20 Silver Birch Drive
Middleton-on-Sea
West Sussex
PO22 6SJ

Ref: PLANNING APPLICATION M/68/20/PL – POULTRY FARM, 87 YAPTON ROAD

I am writing with respect to the above planning application to register the following objections to the plans as resubmitted – previously Application M/80/19/PL, refused in February.

402.06594.00008.RC.TR02.0 - TR03.0.dwg

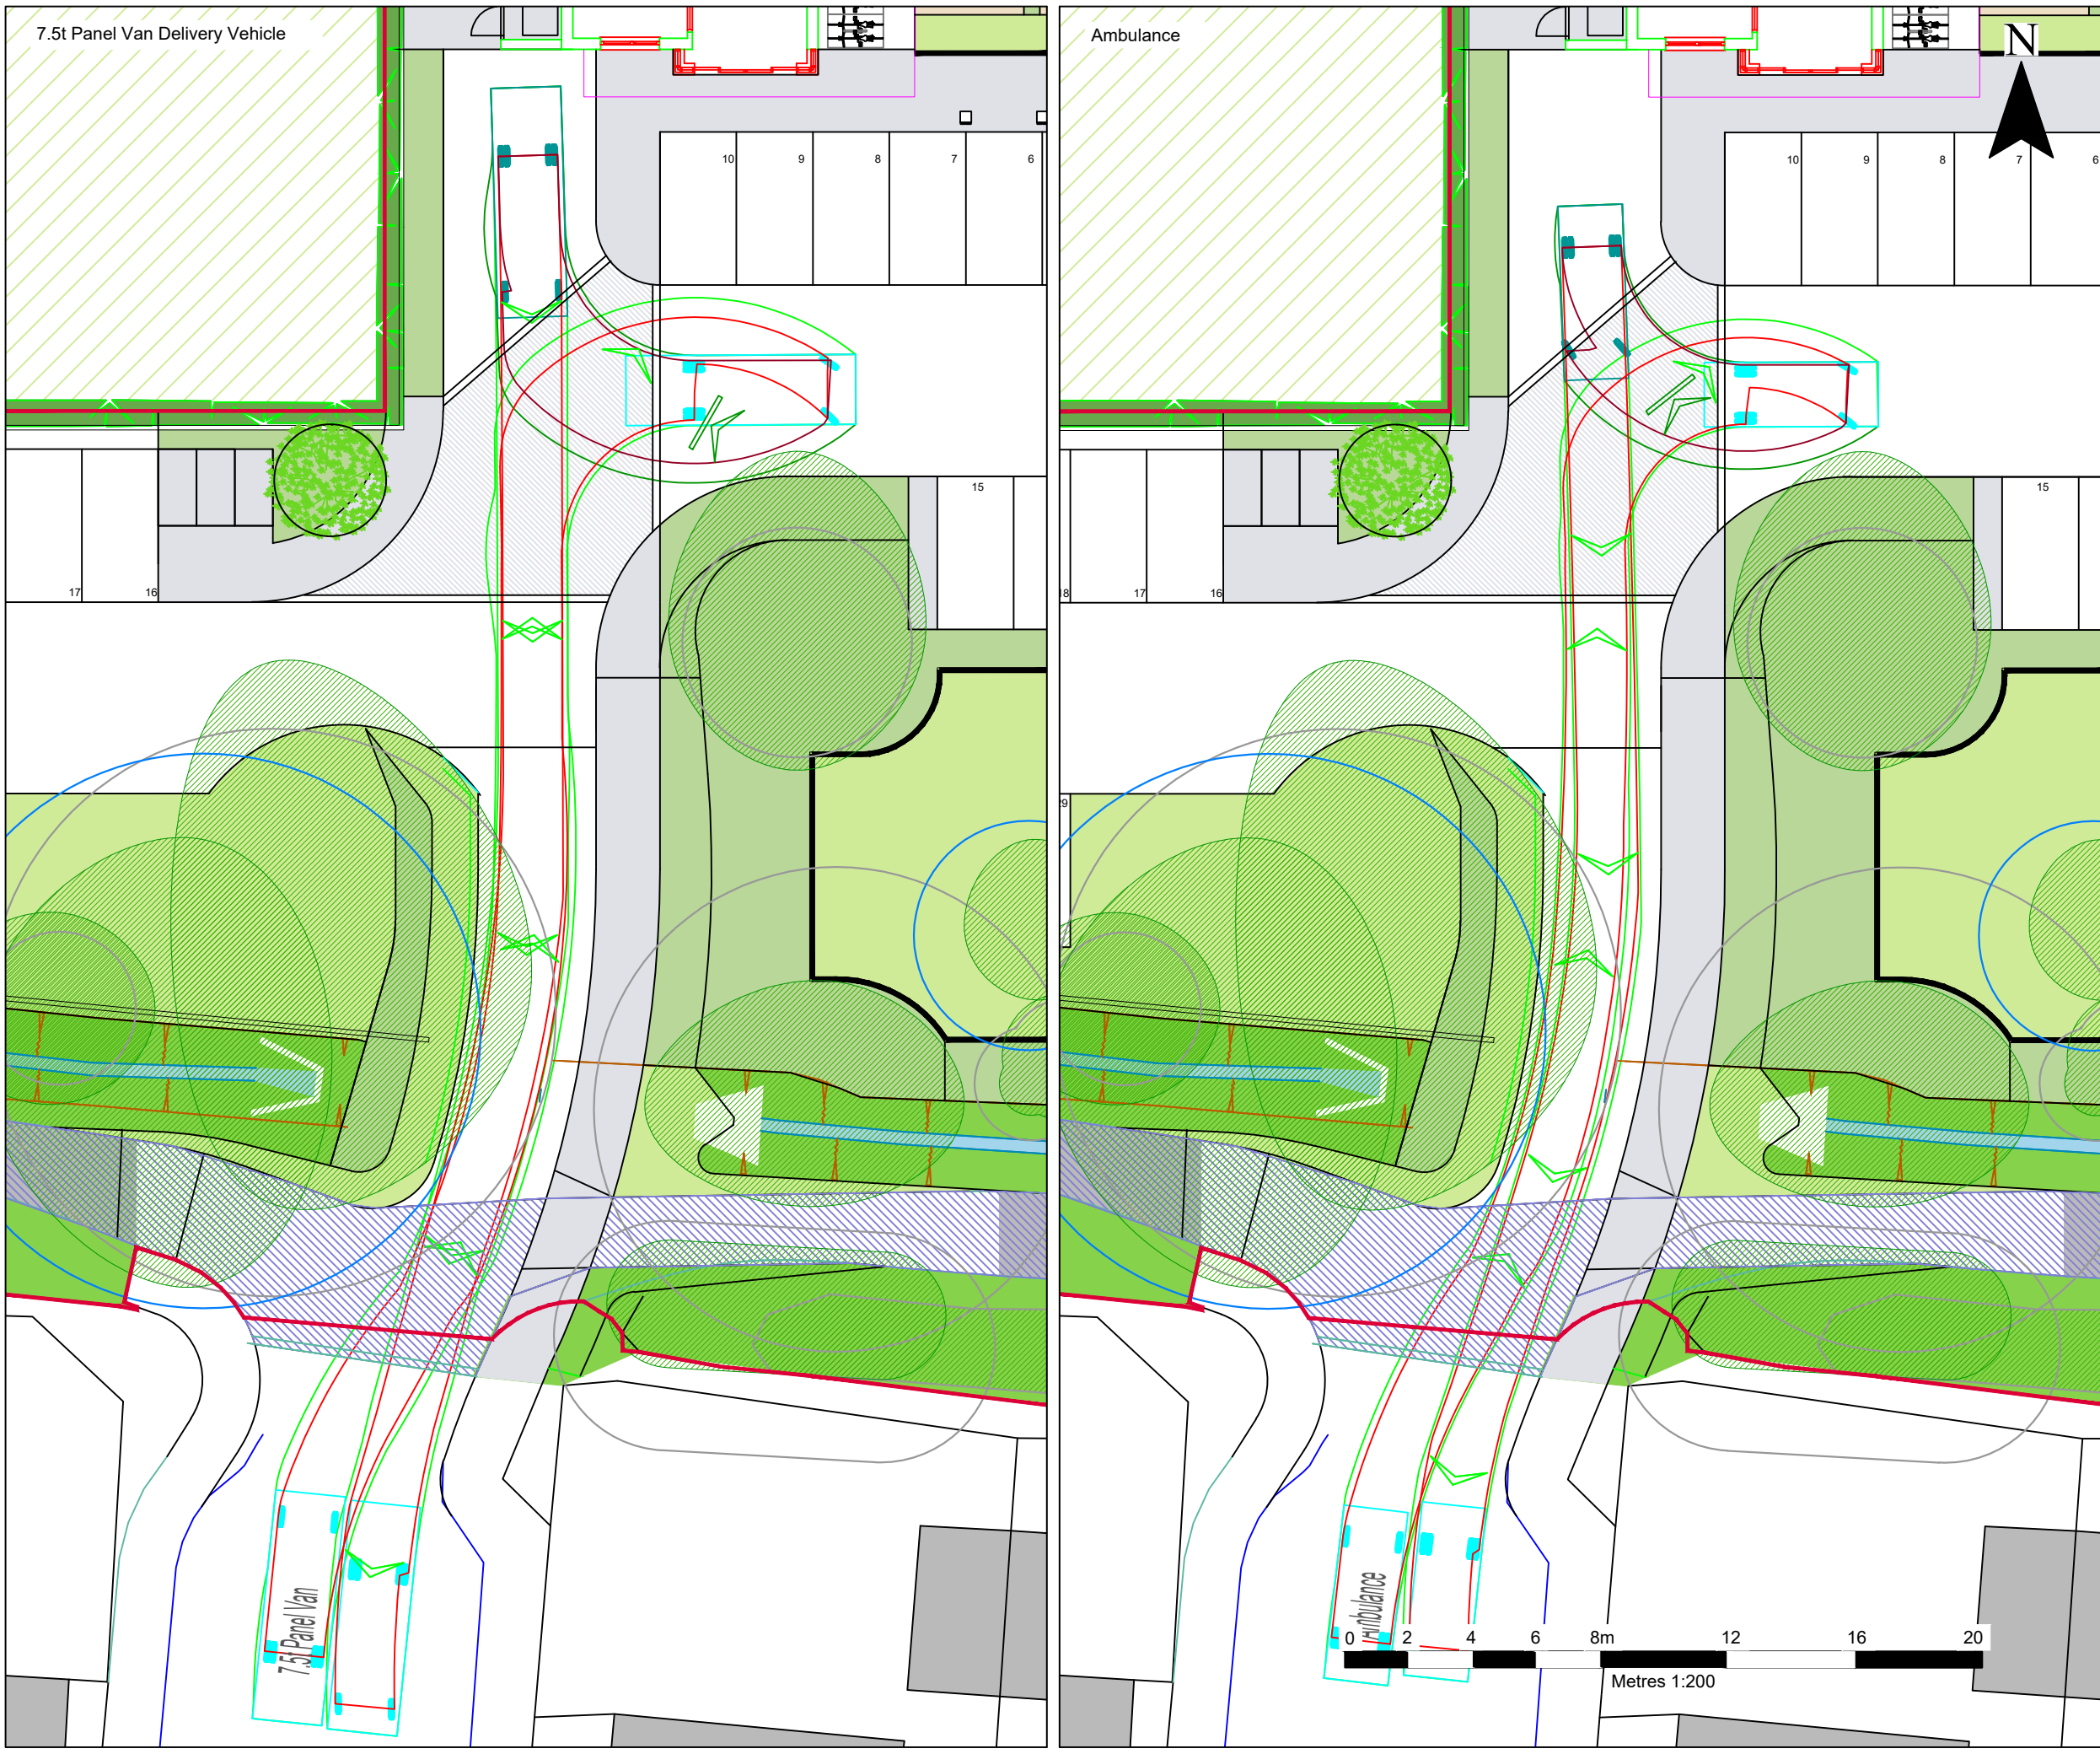
Finally, it is clear that construction access to the site will require far more significant damage to a protected and rarely healthy Ash tree next to the access route than has been set out in documents supporting this application, which refer merely to removal of a low-growth lower limb. For larger vehicles to access the site, **a number of other lower-hanging branches will also need to be removed to the extent that a large part of the lower half of this healthy, protected tree will in fact need to be destroyed.** West Sussex County Council has recently highlighted the threat to our local environment of Ash Dieback disease, saying it has the potential to kill an astonishing 95% of Ash trees in Sussex over the next 10-20 years. **Every opportunity must therefore be taken to preserve, especially if already protected, those that have been professionally judged to be rarely healthy and may be dieback resistant.** Yet this development, via the proposed access route, proposes severe damage to this tree that could threaten its survival.

1. DRAWING PREPARED FOR THE SURFACE WATER DRAINAGE STRATEGY, NOT FOR CONSTRUCTION.
2. ALL LEVELS INDICATED ARE TO OS DATUM (METRES) FROM PROPOSED LEVELS RECEIVED.

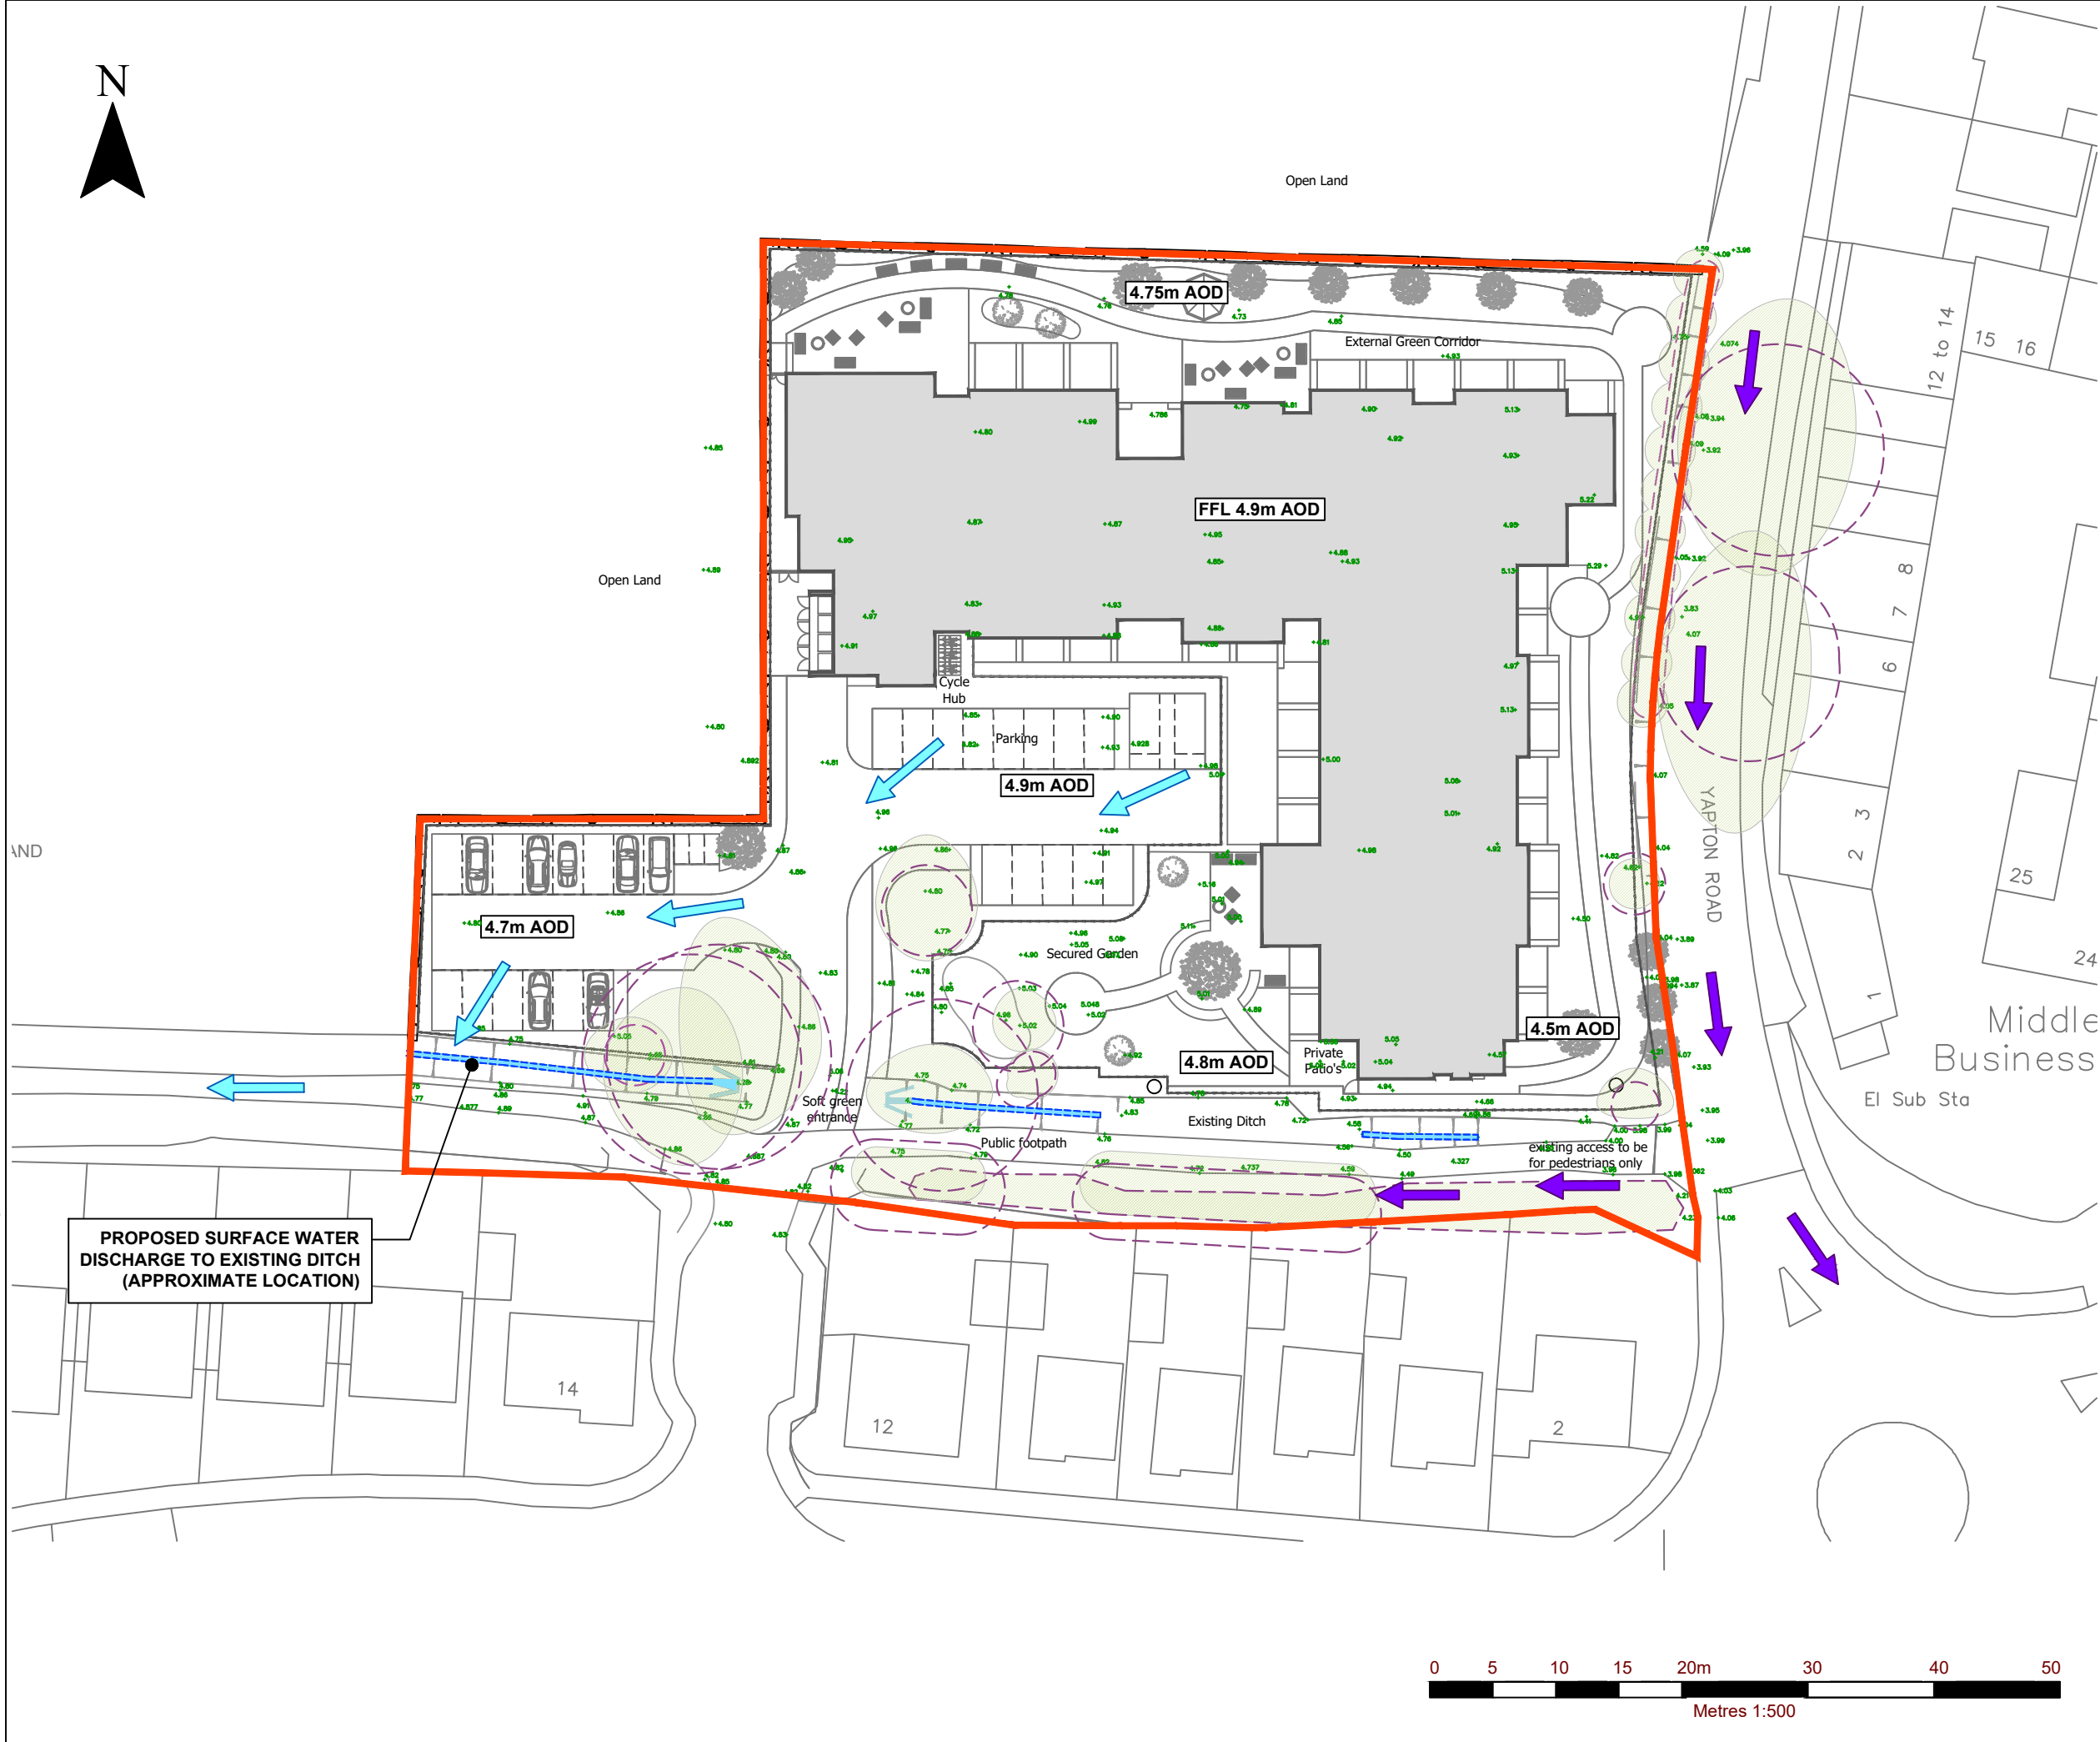
- Since the first application was refused, serious flooding has occurred on Yapton Road adjacent to the eastern boundary of the proposed development at the Yapton Road end of the ditch into which the plans indicate surface water drainage from the new buildings will be directed. Plans to mitigate flooding on the site itself and for surface drainage into the ditch that runs towards an area of previous flooding are therefore only likely to contribute to worsening existing regular incidents of flooding on the neighbouring main road and key route to/from Middleton and Elmer.
